Subject: RE: Westgate - Pre-commencement Conditions

Highways Comments:

Condition 16 (Details of New Retaining Walls):

Local Flood Authority Comments:

Client	Strata Homes					
Project Name	Westgate Cleckheaton					
Description	Silt Mitigation measures - Standard designs					
Dimension	Scale	Size	Project ID	Drawing no.	Revision	File name
m	NTS	A3	302574	24901	C01	302574-DE-249-SS-D-C-24901-C01

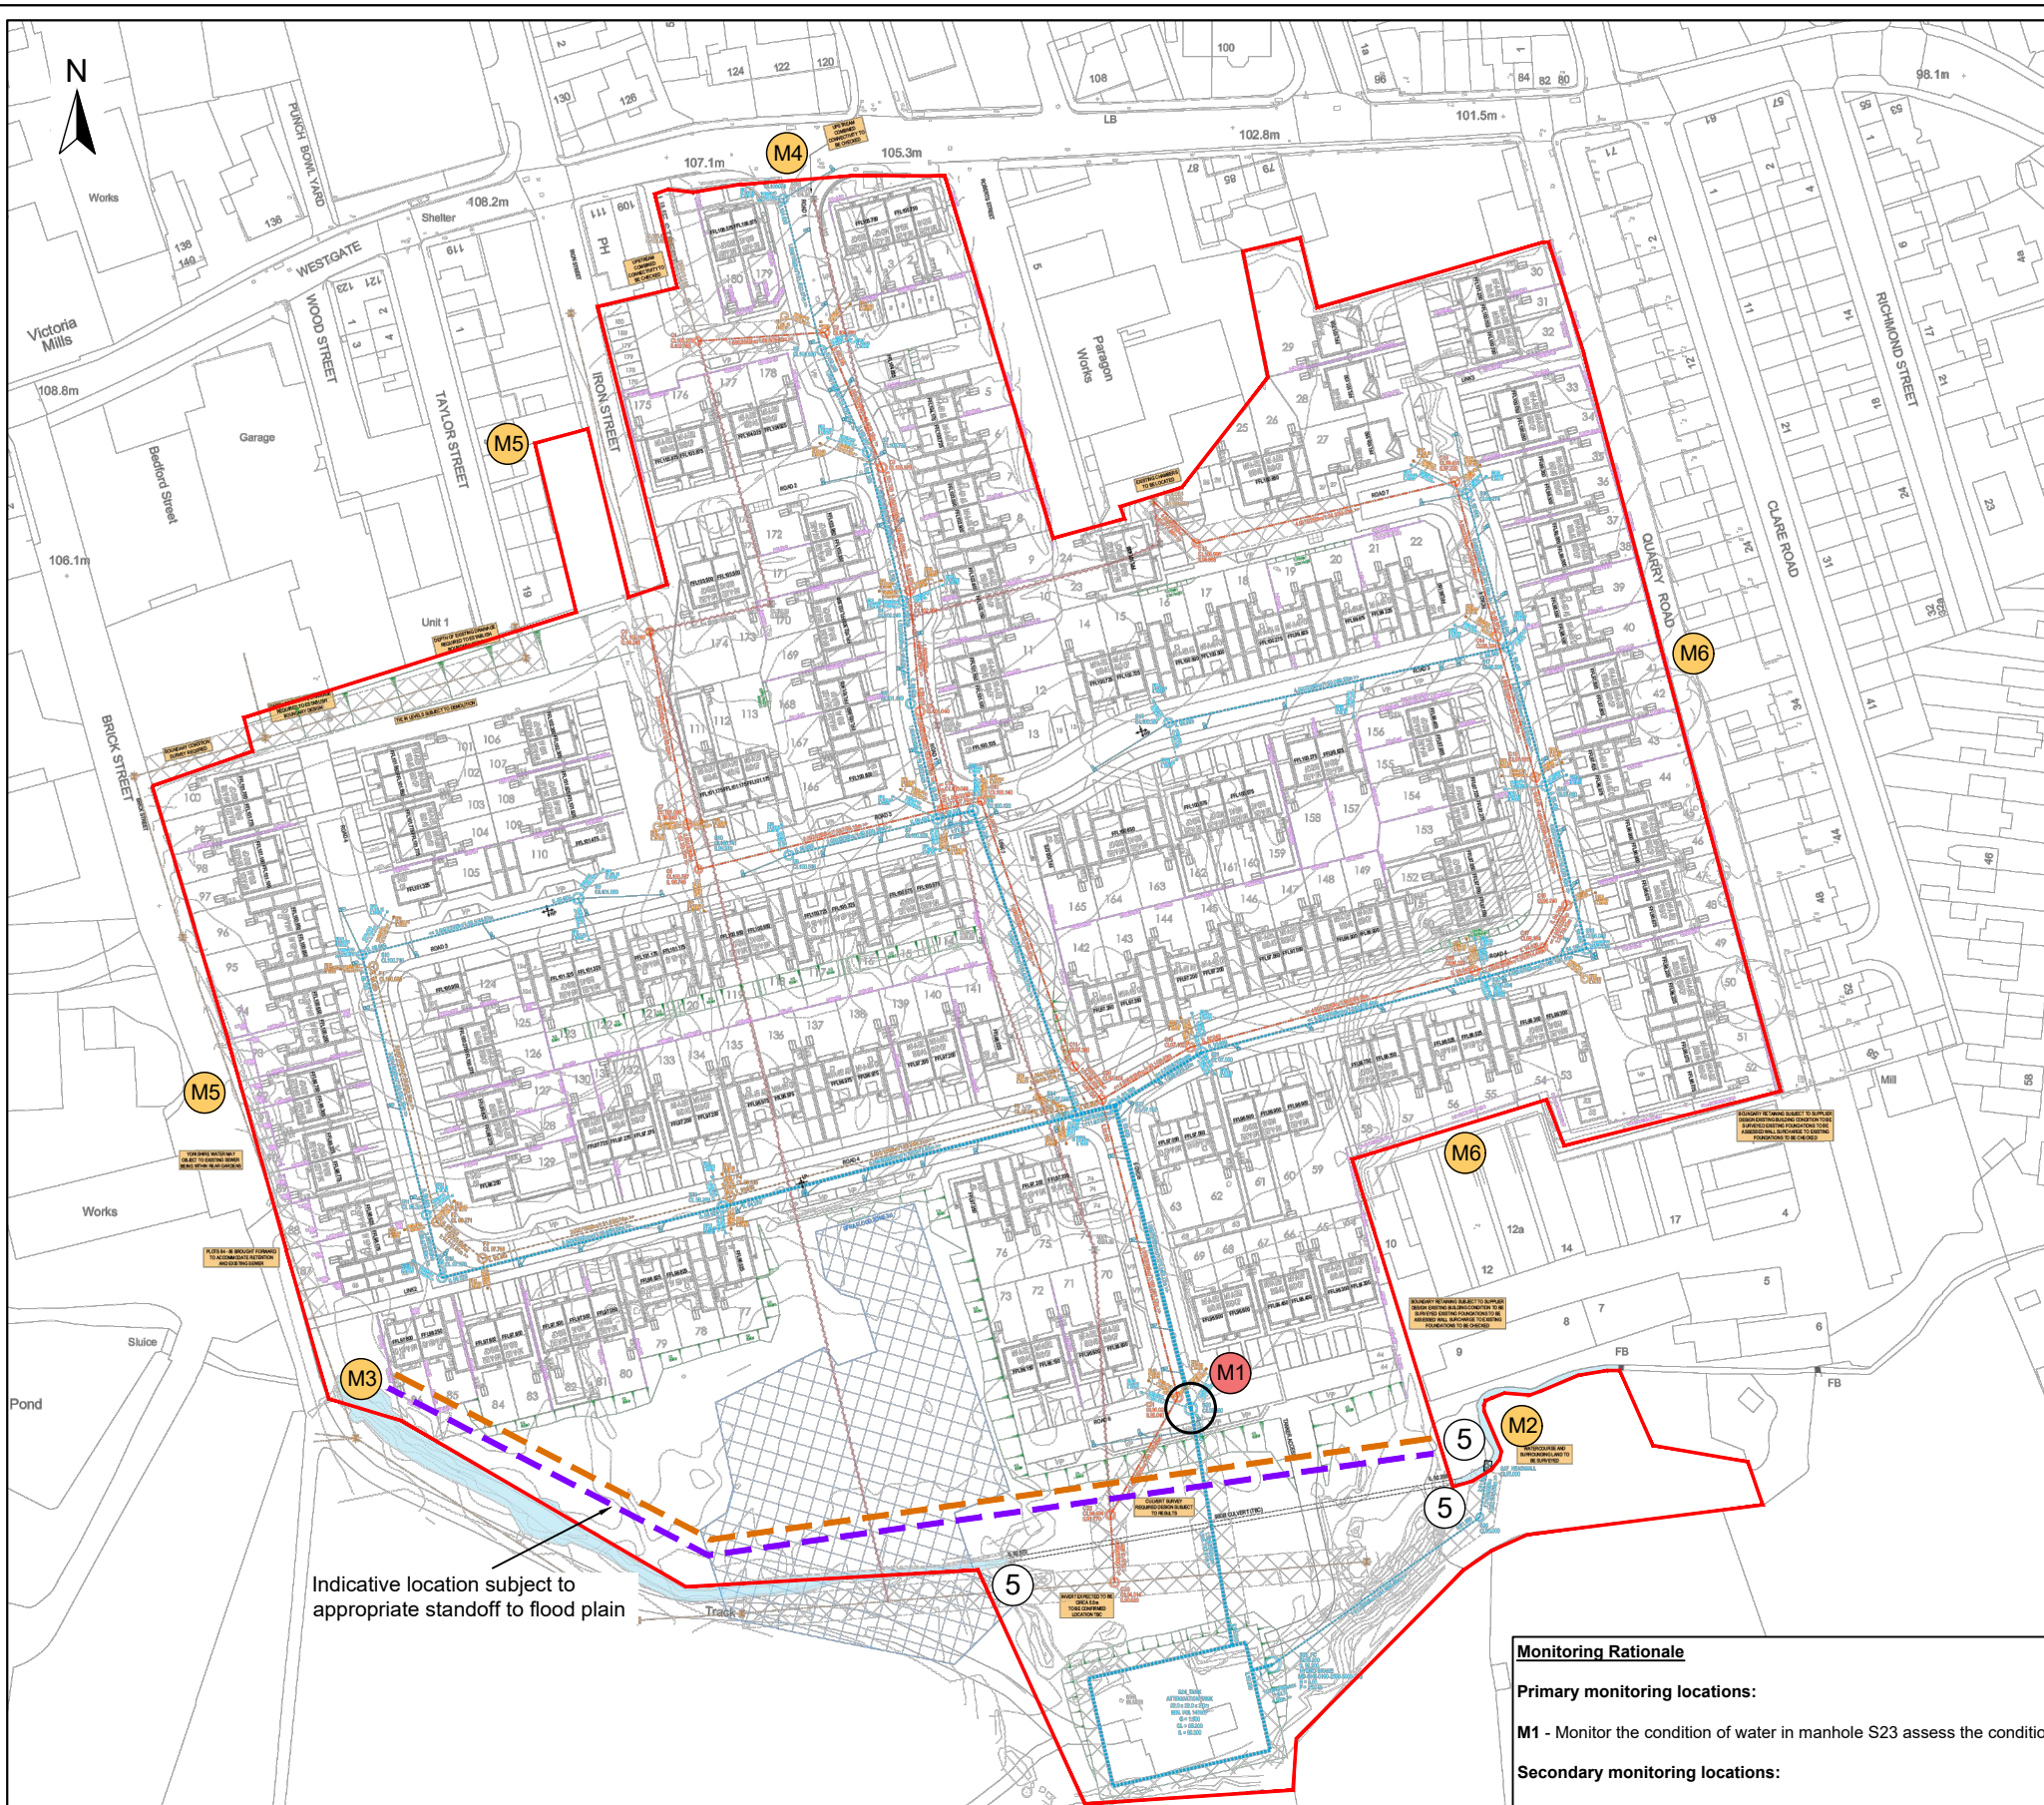
1. Comment: *'We are encouraged by the proposals set out in the 'Surface Water Management Plan', dated October 2023 by RSK Geosciences. Additional information is required.*
 - *Volume of the sumps must be able to contain 1 in 2 year 6 hour storm event. This should be clearly depicted on a plan showing how the site will shed water to each sump.*

2. Comment: *'A cross sectional drawing of the sumps are required as is that of the bunds and fences'*
Response: Following on from the above, sumps are not to be installed as a temporary measure during the course of construction. Page 15 identifies the designs of the silt mitigation measures to be installed on site during the course of construction and provides the requested cross section drawings at items 4 (cut off ditch with rip rap checkdam, bund and silt fence detail), 6 (silt fencing) & 9 (silt fence/straw bail checkdam detail).

Response: Section 6 of the SWMP sets out an extensive list of preventative measures of which are to be installed on site during the course of construction; sumps are not to be installed as a temporary measure during the course of construction and therefore, are not relevant to the discharge of condition 13. Sumps are however, to be installed as a permanent feature once the attenuation tank has been installed.
